ADDENDUM

Re Addendum No. 2 to the Bidding Documents for:

USM
Central Heat Plant Upgrades
Portland, ME
Project No. 14411

Addendum No. 2

FIRST FLOOR PIPING PLAN

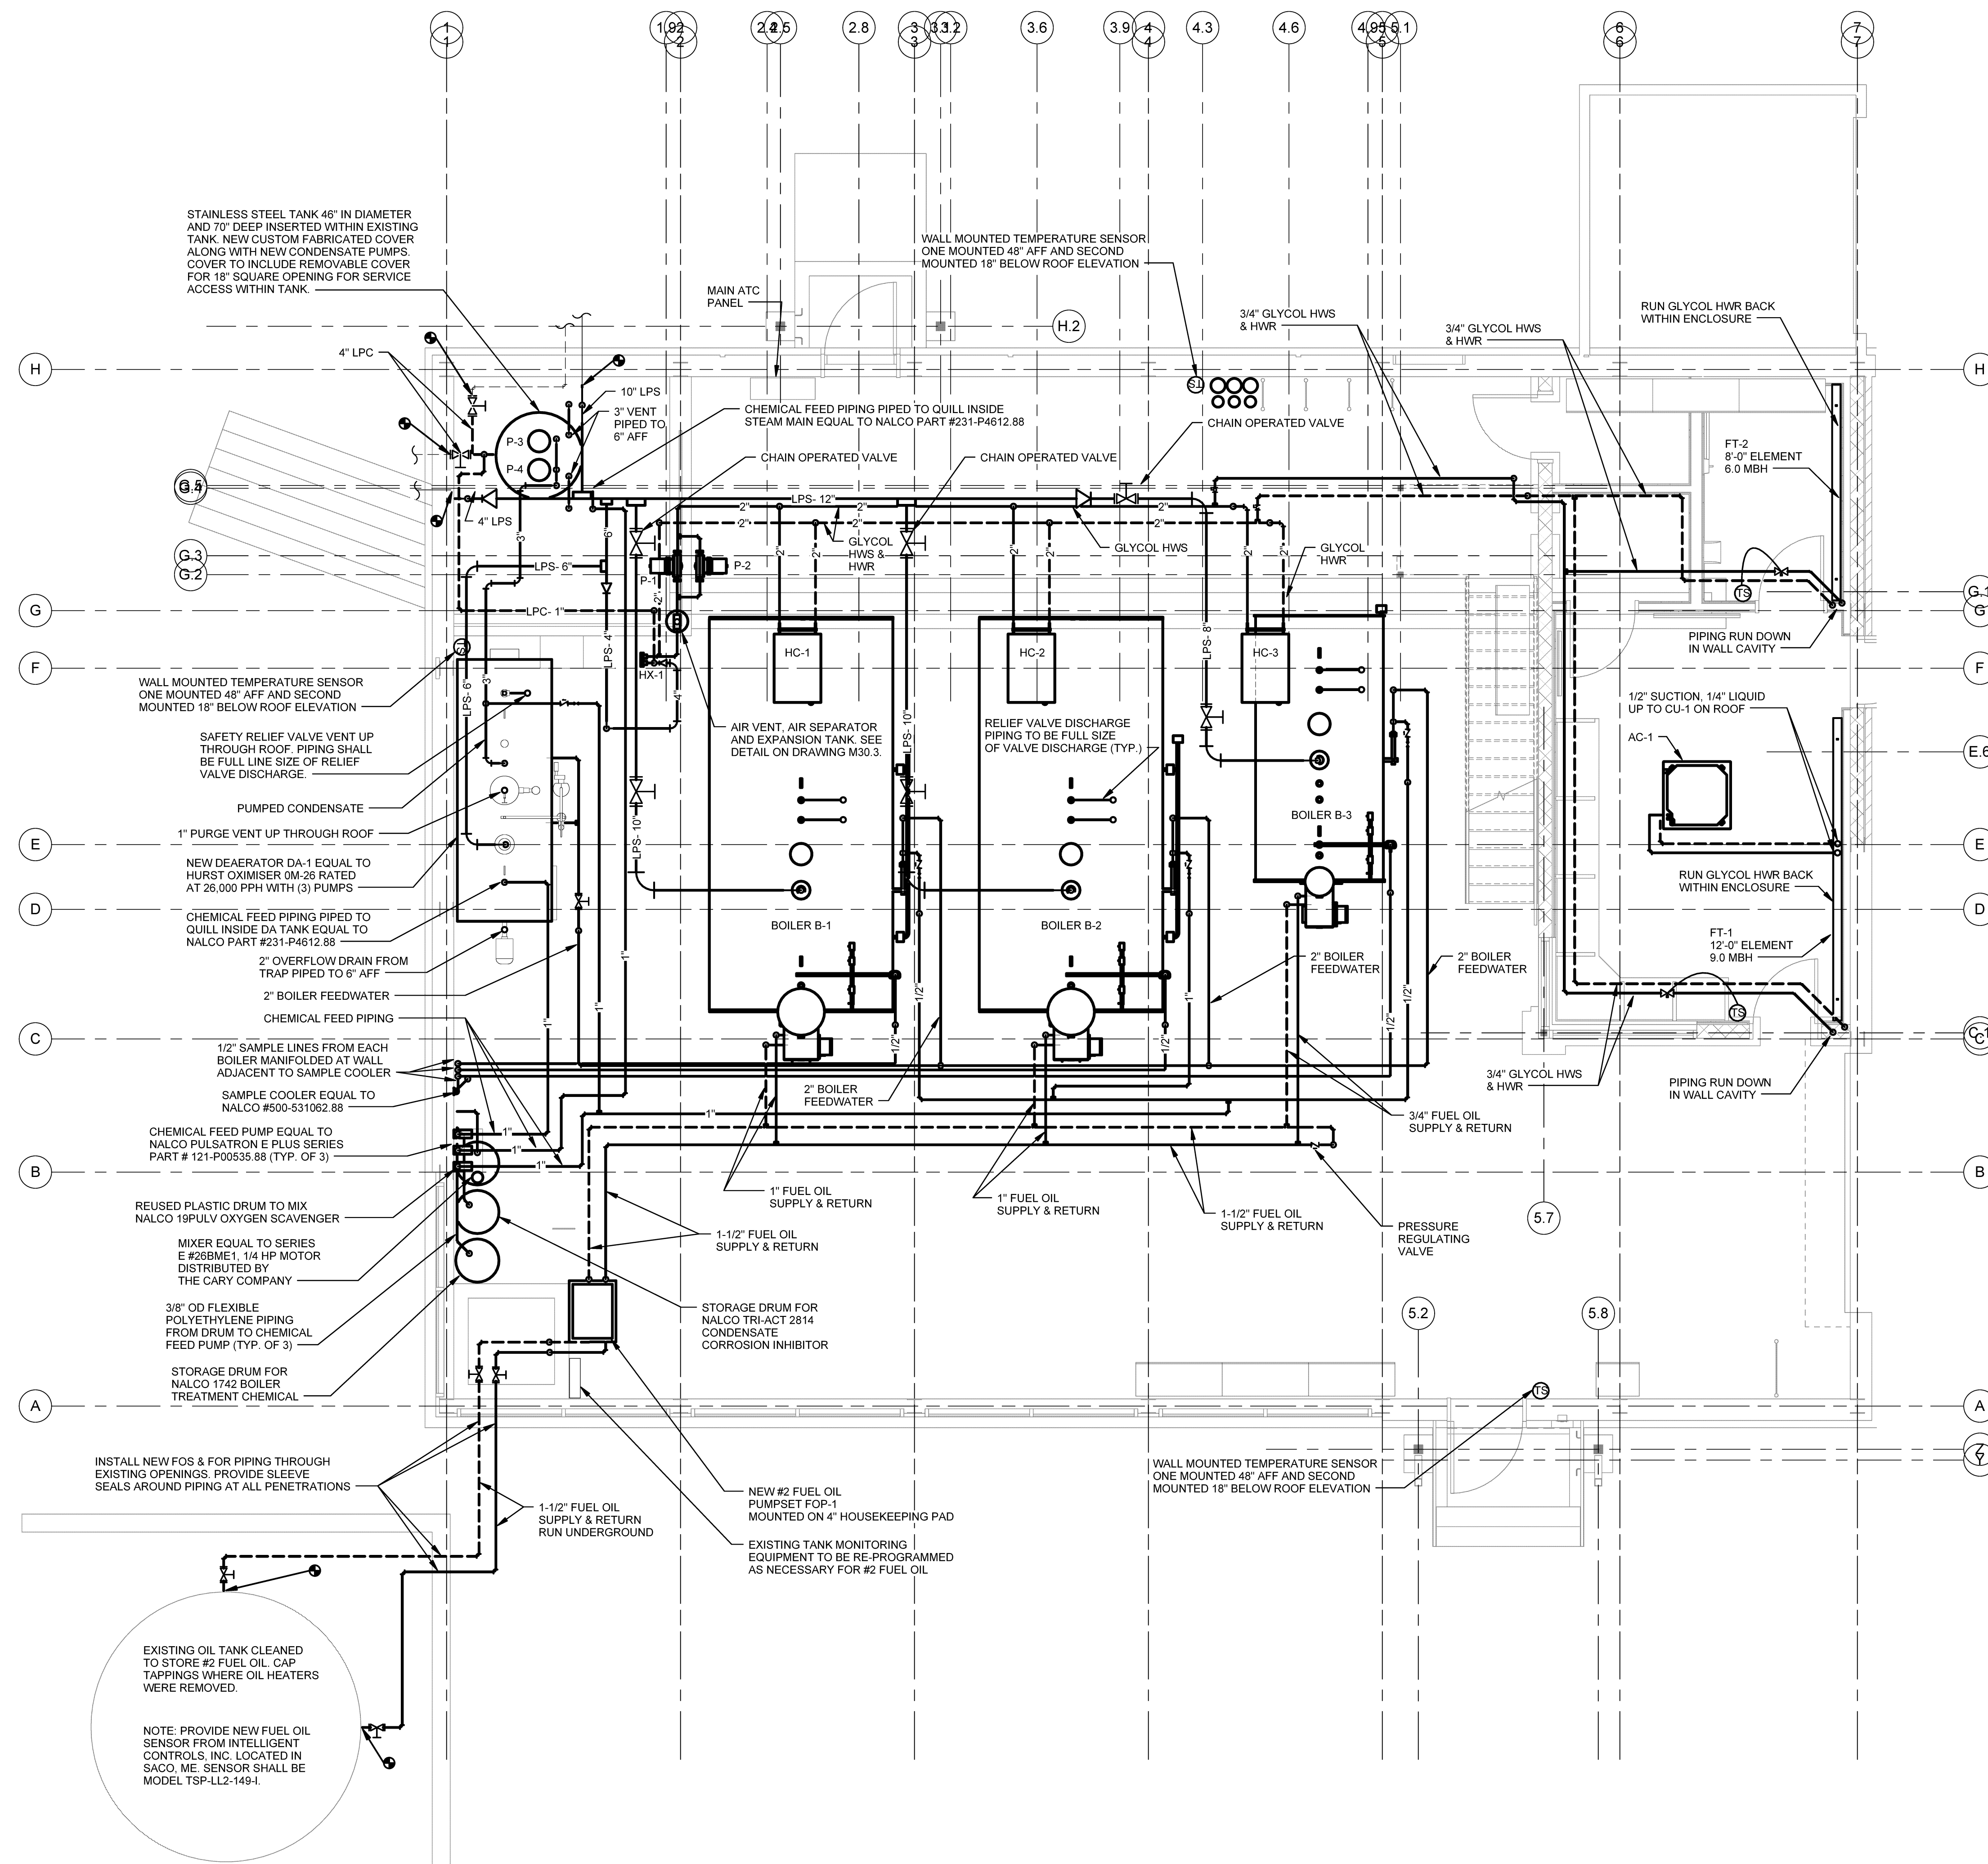
- a. Question: Should there be isolation at the 4" & 10" steam meters / mains, feeding out of the building? None is shown.
Answer: Yes, provide isolation valves for the 4" and 10" steam mains leaving the Central Heat Plant.
- b. Question: Is the fuel oil 'tank monitoring equipment reprogramming' to be done by BMS? If not who is the equipment software currently maintained through?
Answer: Mechanical Contractor is responsible for reprogramming tank monitoring equipment. Mechanical Contractor shall coordinate with Intelligent Controls Inc., Saco, ME.
